Development Control
Ribble Valley Borough Council

Re: Planning Application 19/0666

Address: Land south of Lower Road Hothersall PR3 2YY

Description: Erection of business units (use class B1 and B8) comprising three new buildings with access, parking and provision of secure compounds.

**VISIBILITY**

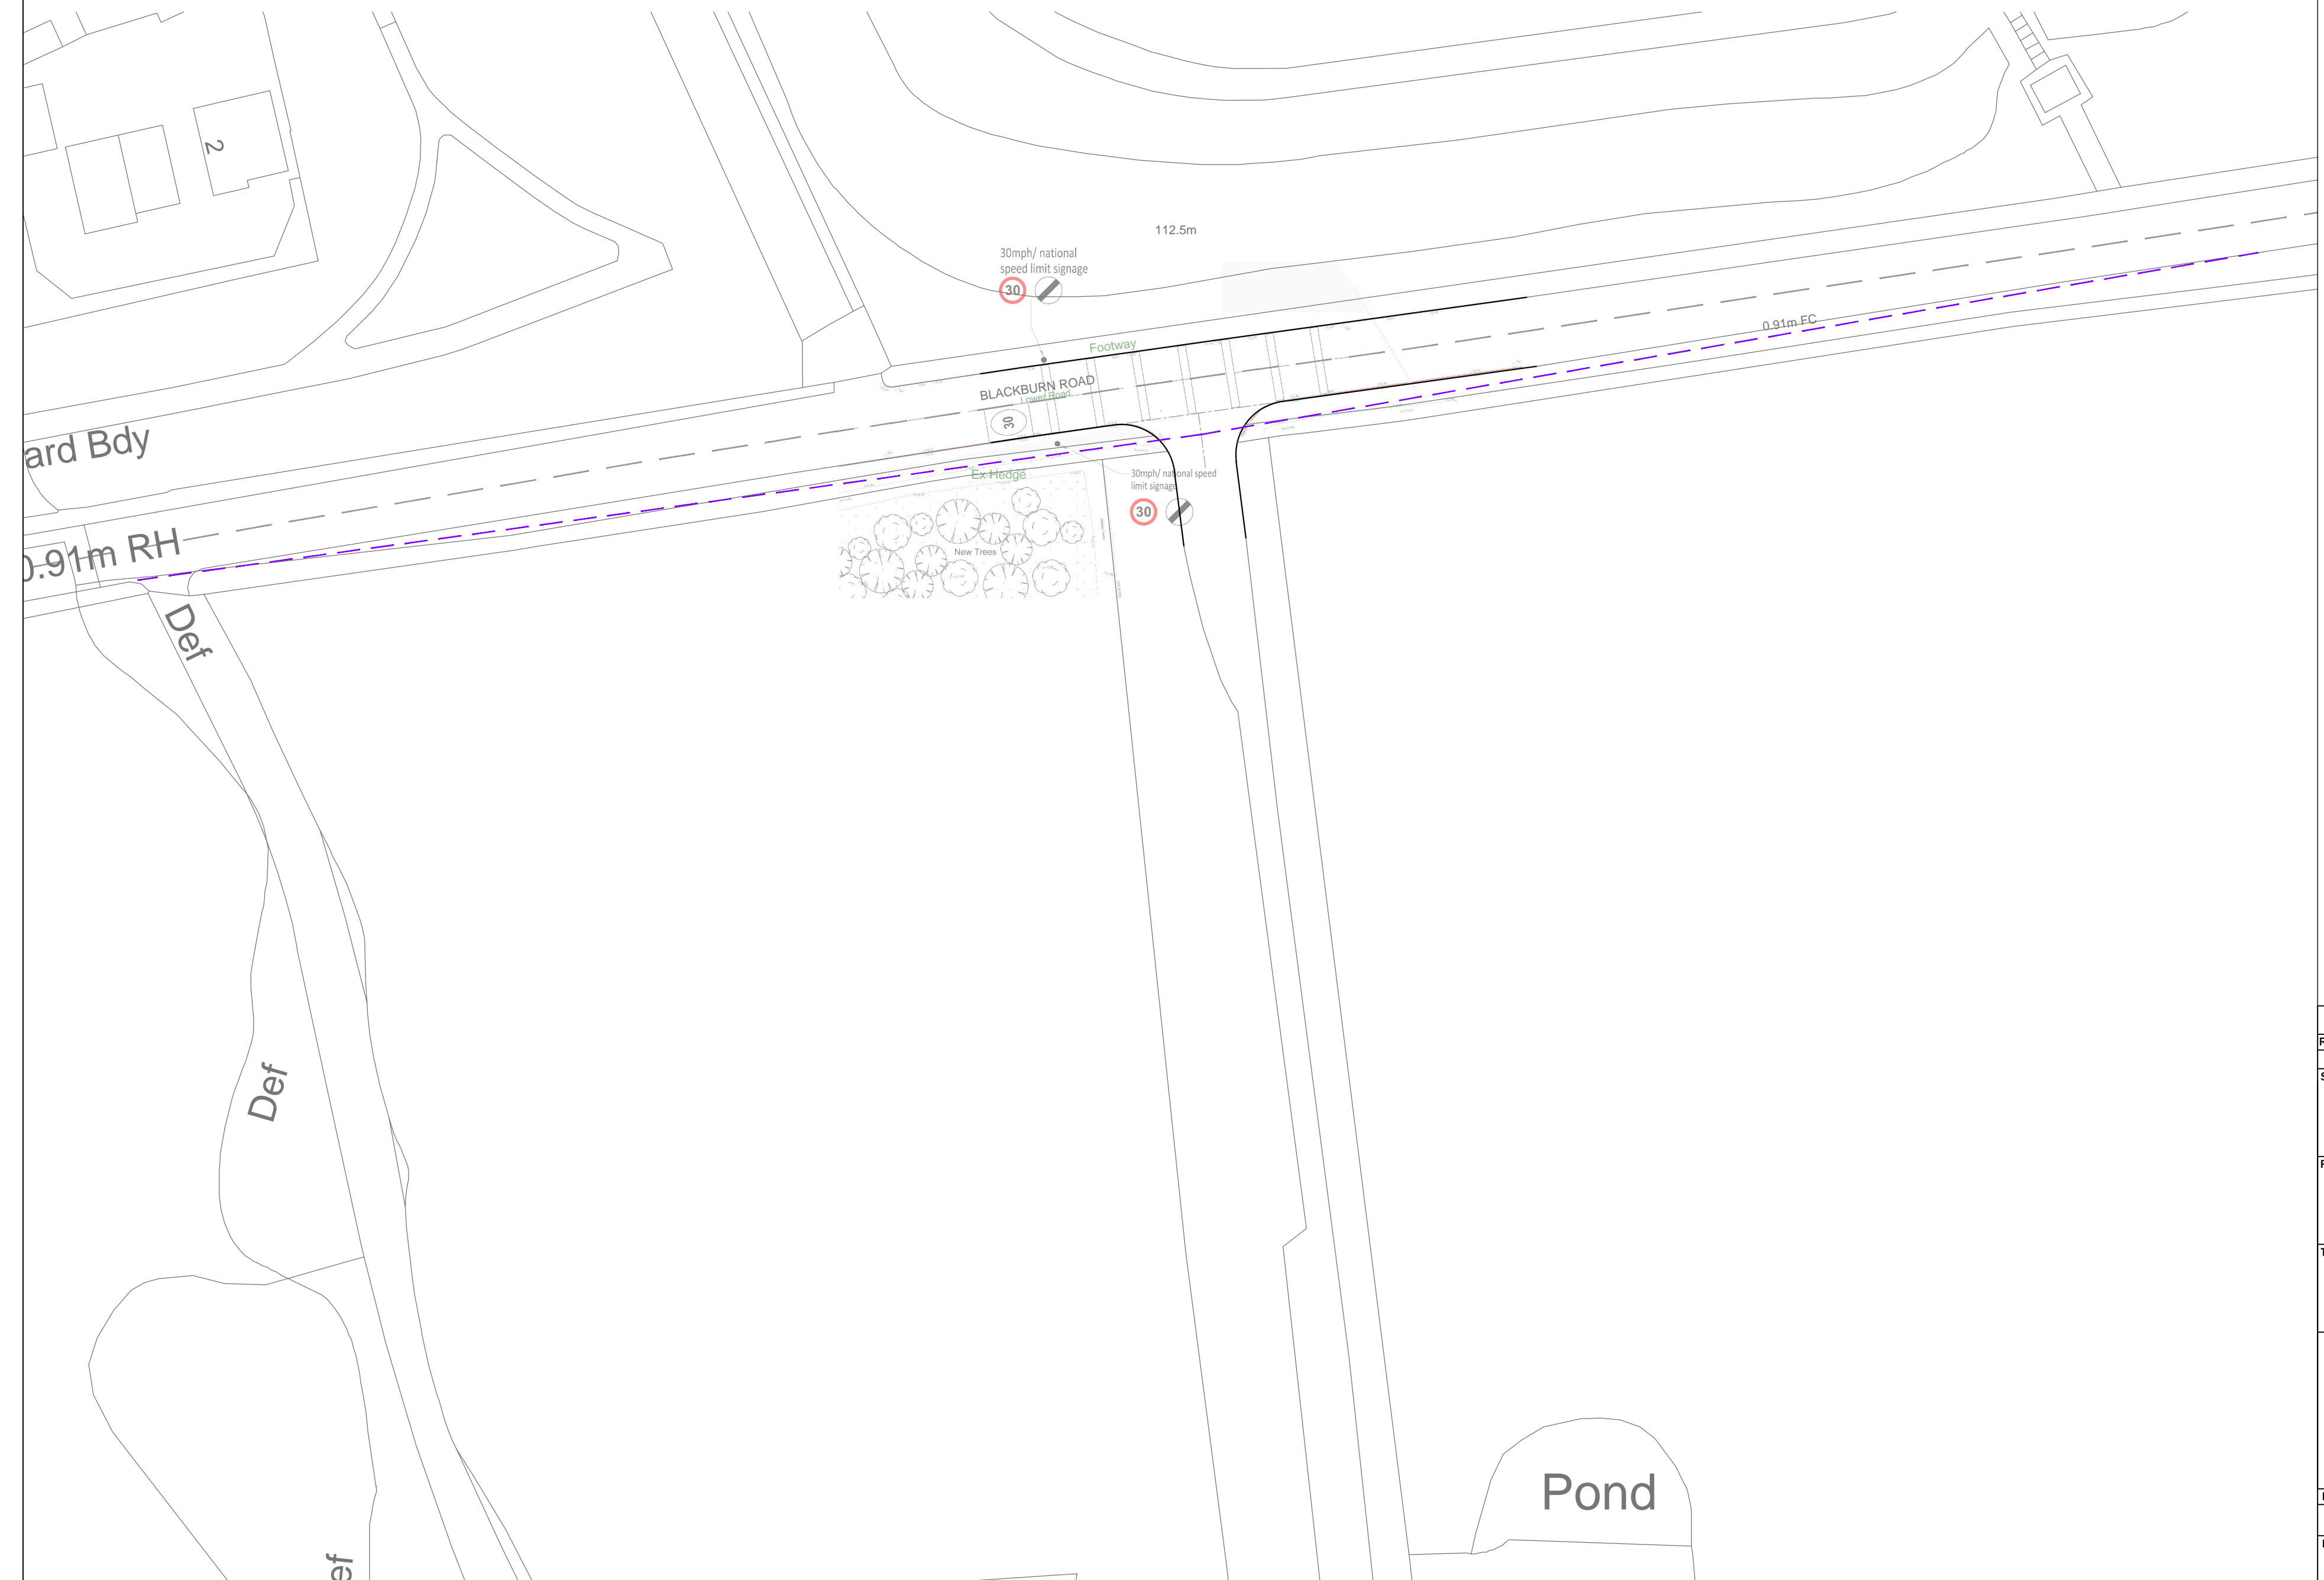
- A swept path analysis showing that a 12m 24 tonne rigid vehicle can exit and entre the site without crossing the centre line of Blackburn Road when exiting towards Preston
- A second swept path for an articulated vehicle with a standard 12m container will also be required
- A Construction Management plan for the development, any works should not impede the existing business
- A 7 day traffic count is required to establish the 85th percentile speed required for a visibility splay. It is noted that the 30mph limit has moved due to the recent housing development
